Department of Transportation

December 15, 2022

RE: Villages at Waterview North - EGP214

I am in receipt of a referral request for comments for Villages at Waterview North on Highway 21A, that is requesting approval of the Master Plan, Concept Plan and Zone Change for 116.53 -acres of property under review to approve zone changes of the approved Waterview Sketch Plan Amendment area to industrial, commercial, and residential land uses. The project proposes to set the framework for the mixed-density residential development located in the north central portion of the Villages at Waterview North Master Plan. The goal of the project is to develop an integrated patchwork of residential neighborhoods that offer a variety of housing options. The overall project is estimated to provide approximately 800 residential units. The site is located at the north-east quadrant of the intersection of SH21A and Bradley Rd. in in El Paso County. After review of all documentation, we have the following comments:

DRAINAGE EXHIBIT – WATERVIEW NORTH COLORADO SPRINGS, CO

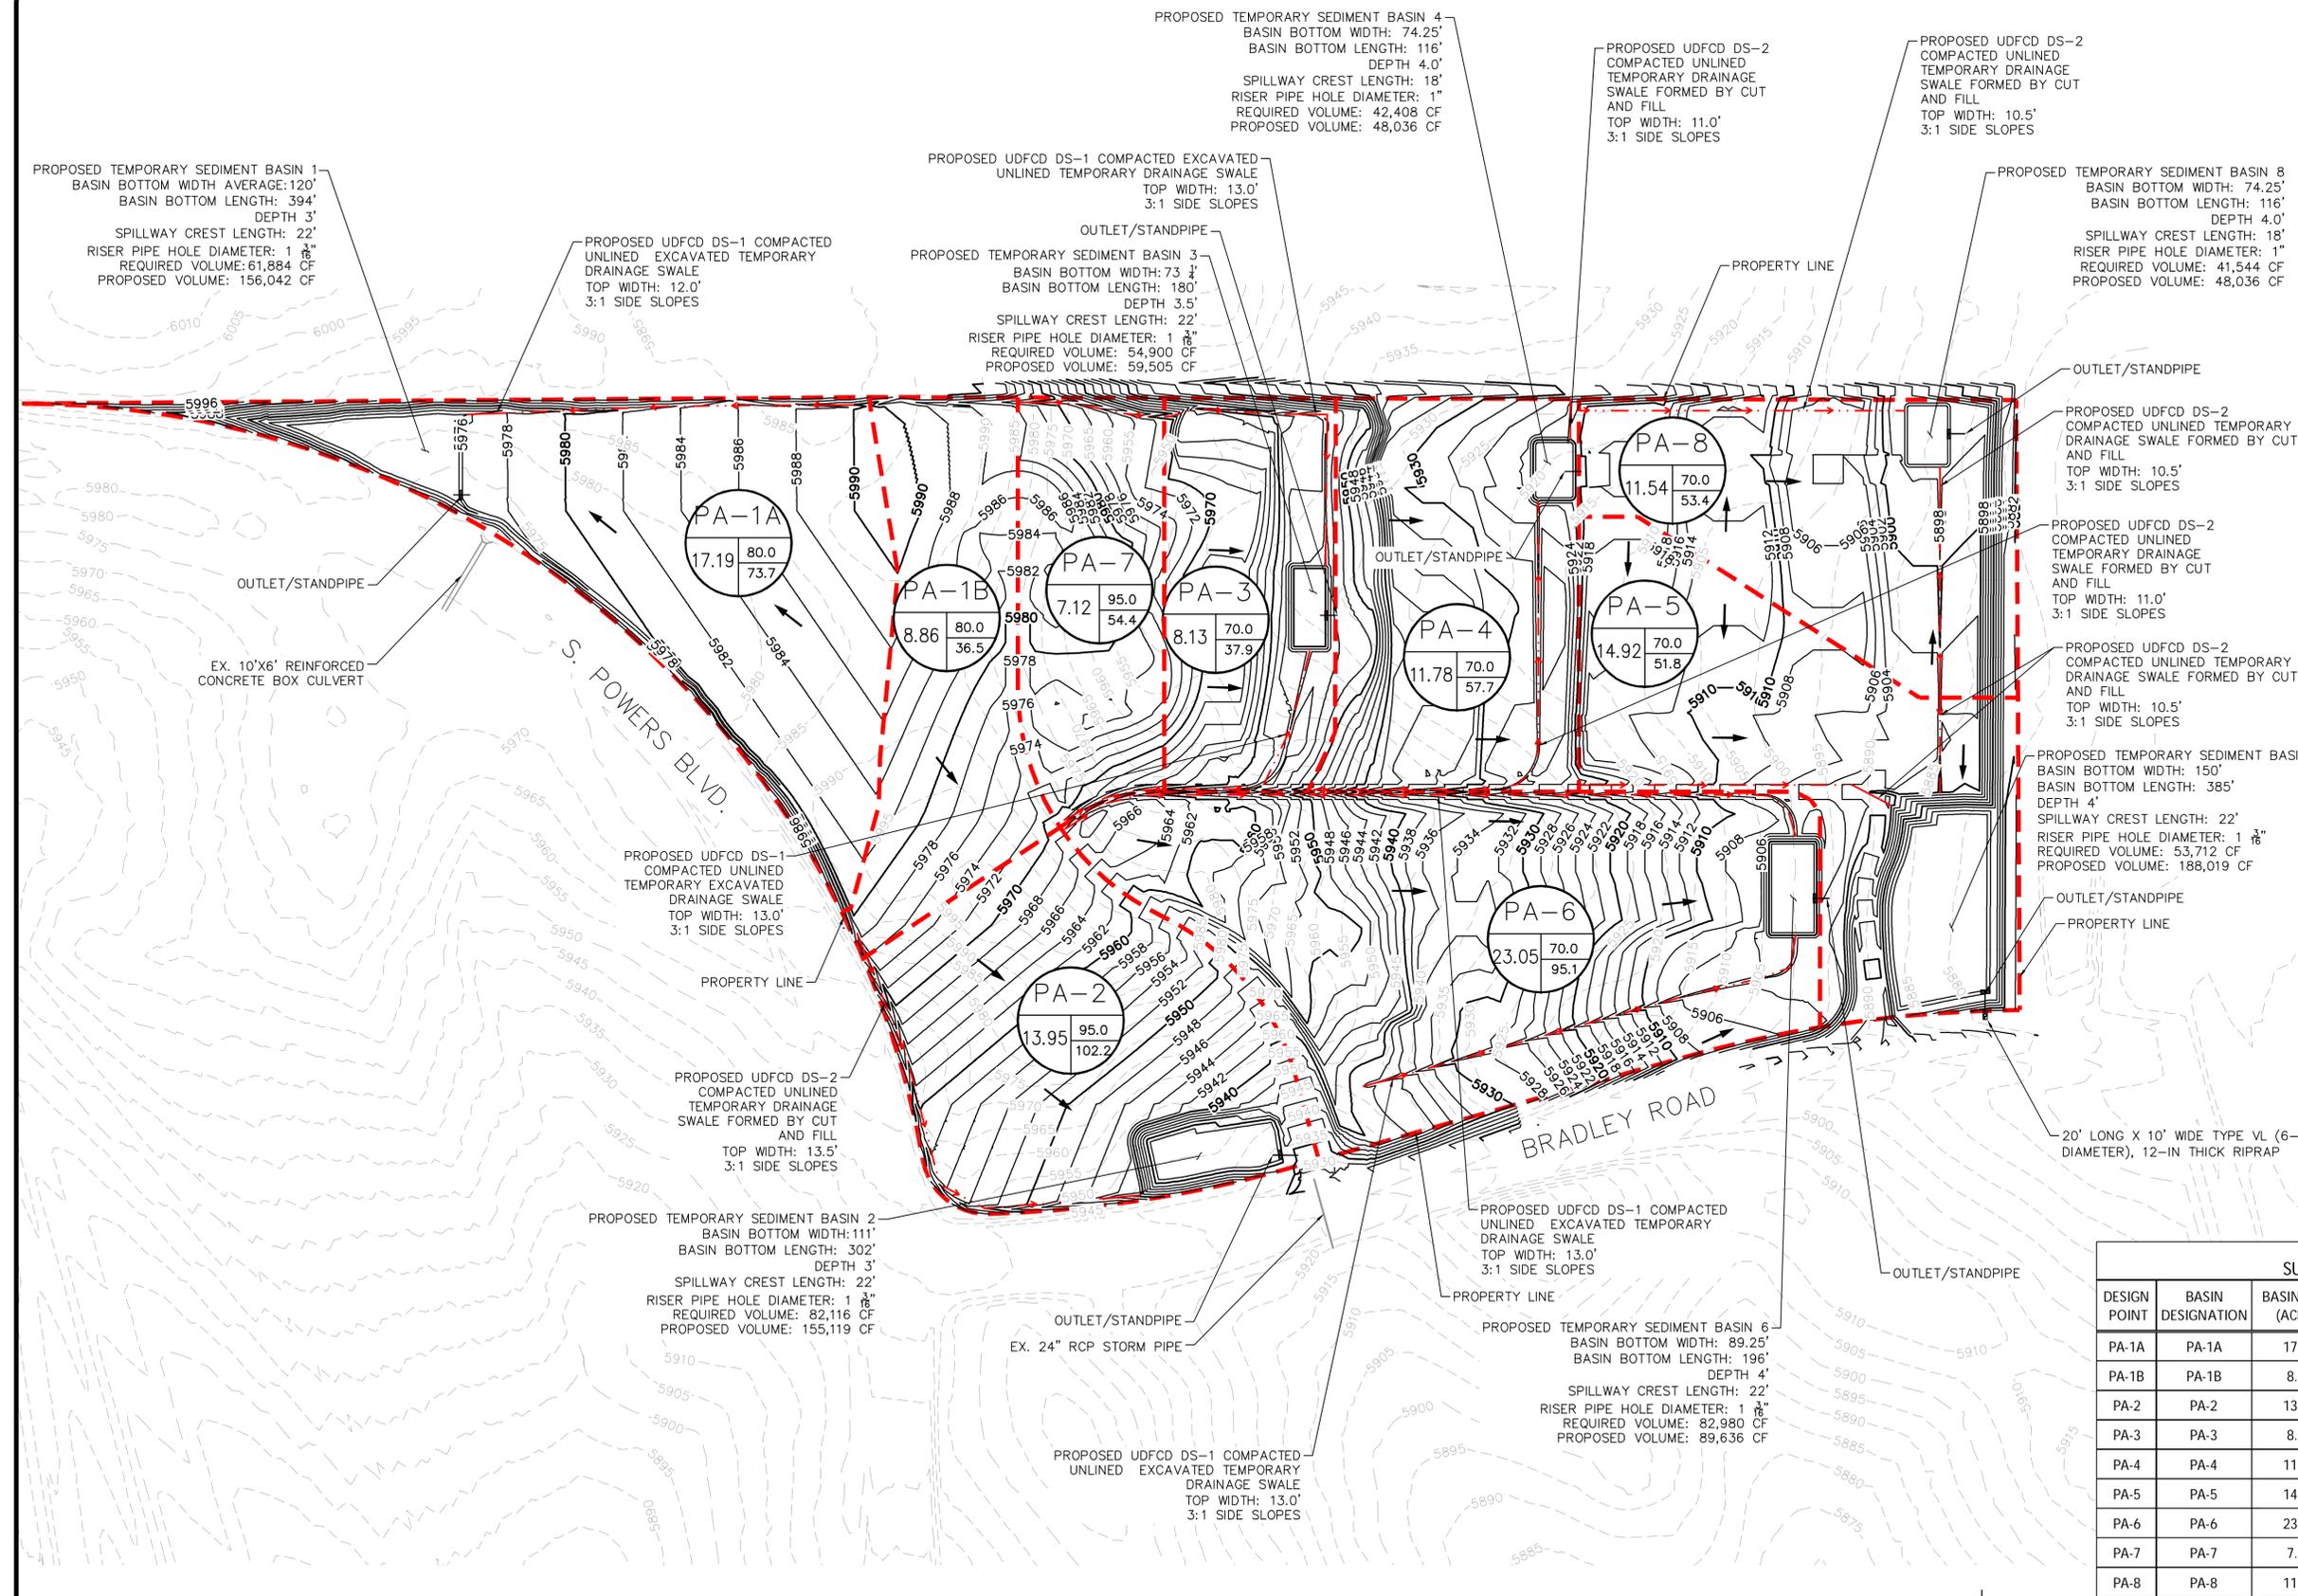
- Please provide an analysis of the existing and temporary/proposed flowrates to the concrete box culvert on Powers.
- The report indicates the temporary sediment basins were provided for the initial erosion control permit, and that they were sized based on the MHFD fact sheet. It appears that some of the contributing drainage areas are larger than those shown in the standard sizing table. Please include documentation supporting the larger sized sediment basins.
- The northern areas that drain to the site do not appear to be included on the temporary conditions' drainage map (drainage exhibit). Please confirm if these are included in the

- temporary conditions (sediment basin) sizing. If they are not included, TSB 1 would not be properly sized and would appear to overflow onto Powers Blvd. In this case the TSB should be revised.

- The spillway for TSB appears to discharge directly onto Powers. Please confirm if this is not the case, or please revise to no impact Powers.
 - The swale calculations include a depth of flow in each swale. Please include height dimension for each swale on the drainage exhibit to confirm there is adequate capacity.

- Please be sure that the required volume shown on the drainage exhibit for the sediment basins match what is shown on previous plans or discuss the discrepancy.
